Date: 31st July 2020

Our Ref: AL/36/20/DOC

Town & Country Planning Act 1990 (as amended)
Town and Country Planning (Development Management Procedure) (England) Order 2015
Approval of details reserved by condition imposed under ref AL/34/17/HH relating to Condition Nos 3 -
materials & finishes and 4 - surface water drainage.
The Studio Tudor Drive Westergate Aldingbourne PO20 3YT

scale	date	
1:100 @ A3	October 2019	
job no	drawing no	rev
19150	03.05	A

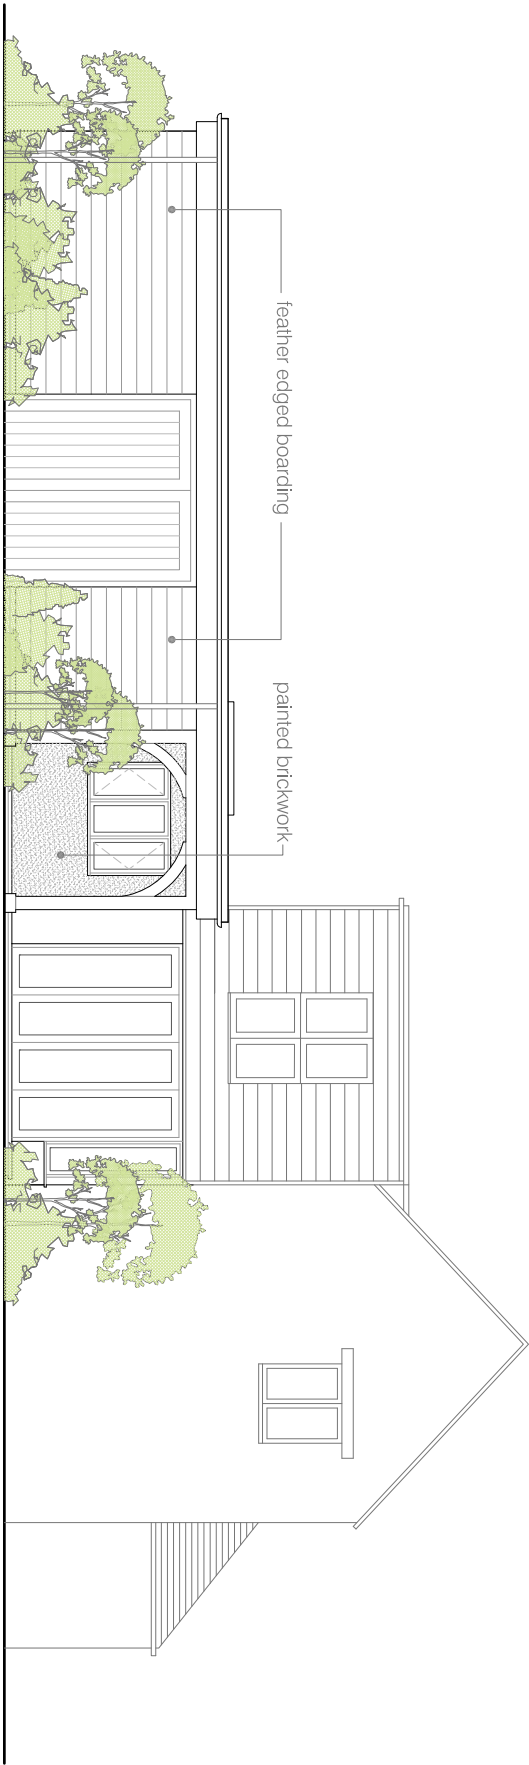
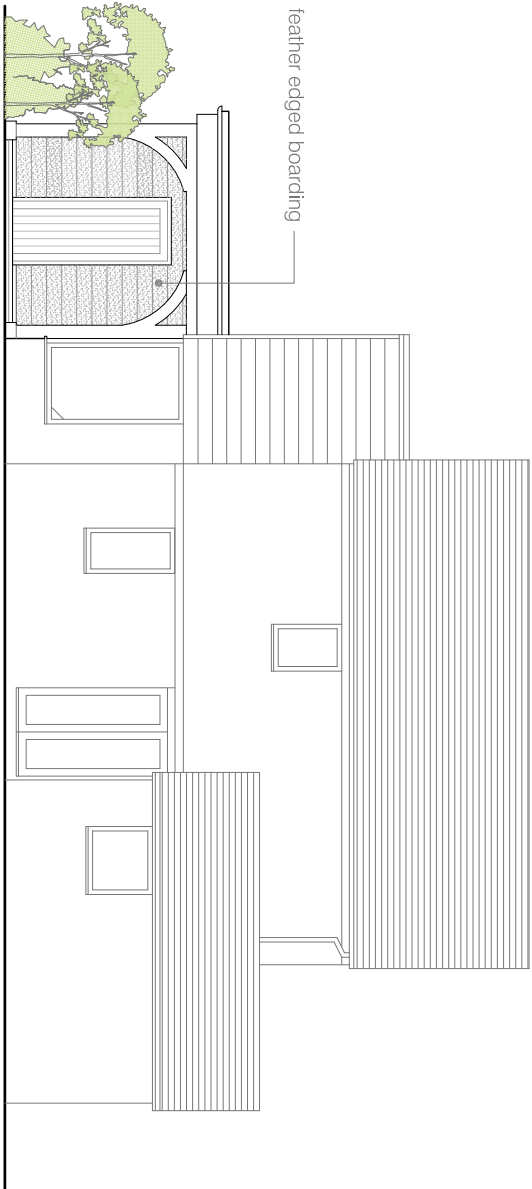
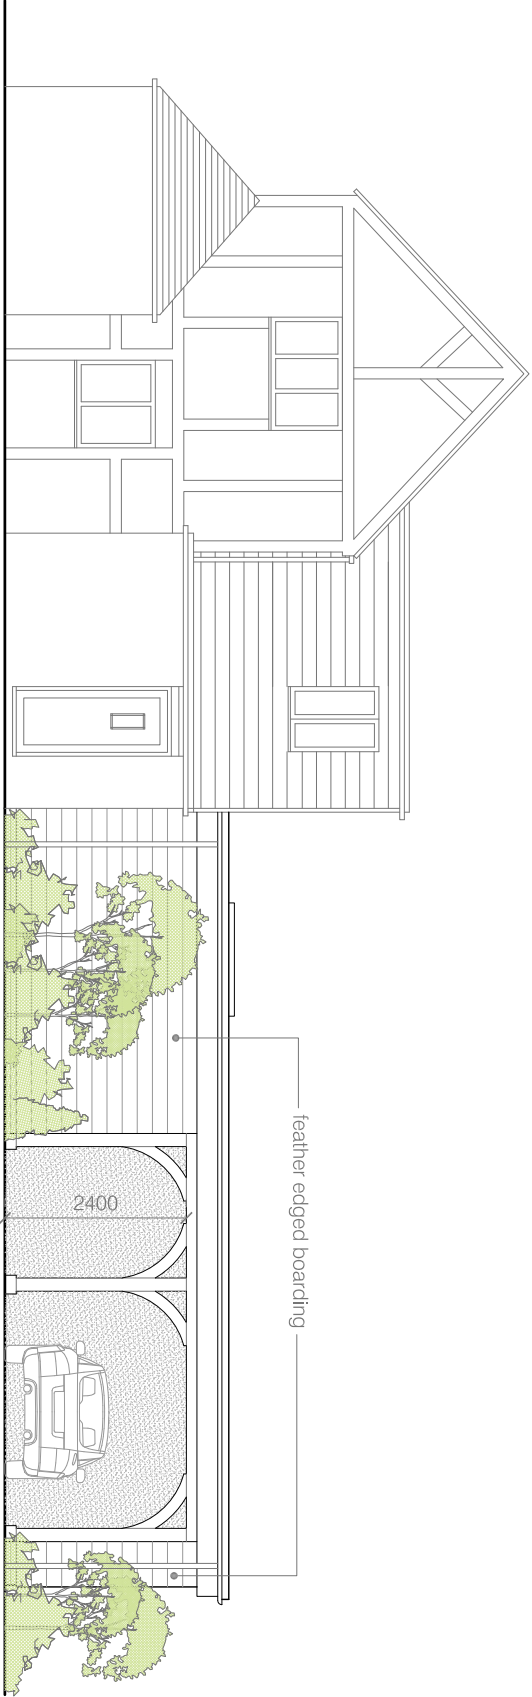
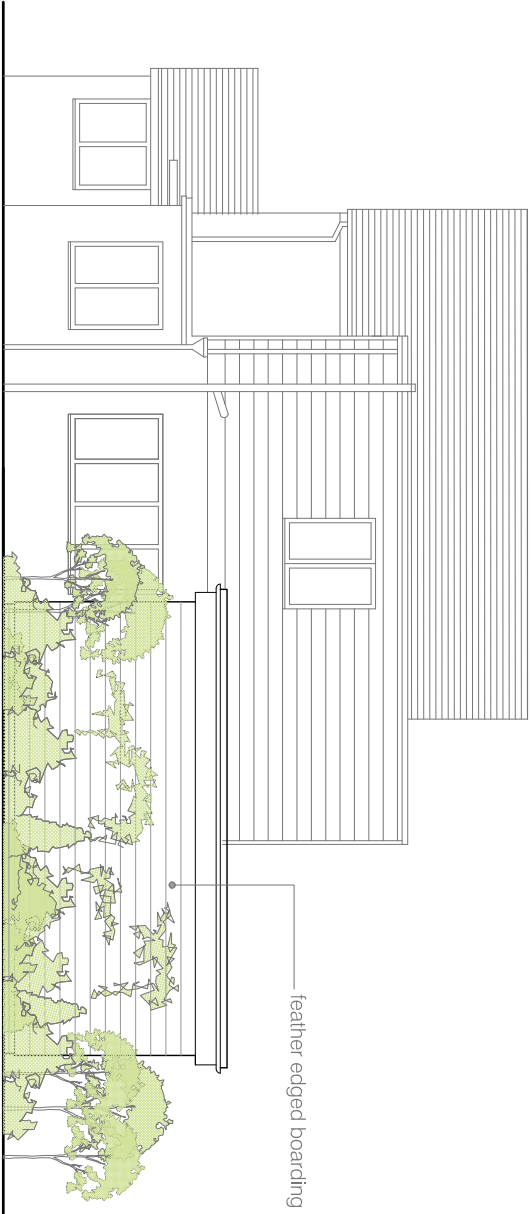
The details submitted in respect of the external walls and roofs namely the Colour Materials Schedule (ref 19150) are considered to provide an acceptable scheme and satisfies the requirements of the condition.
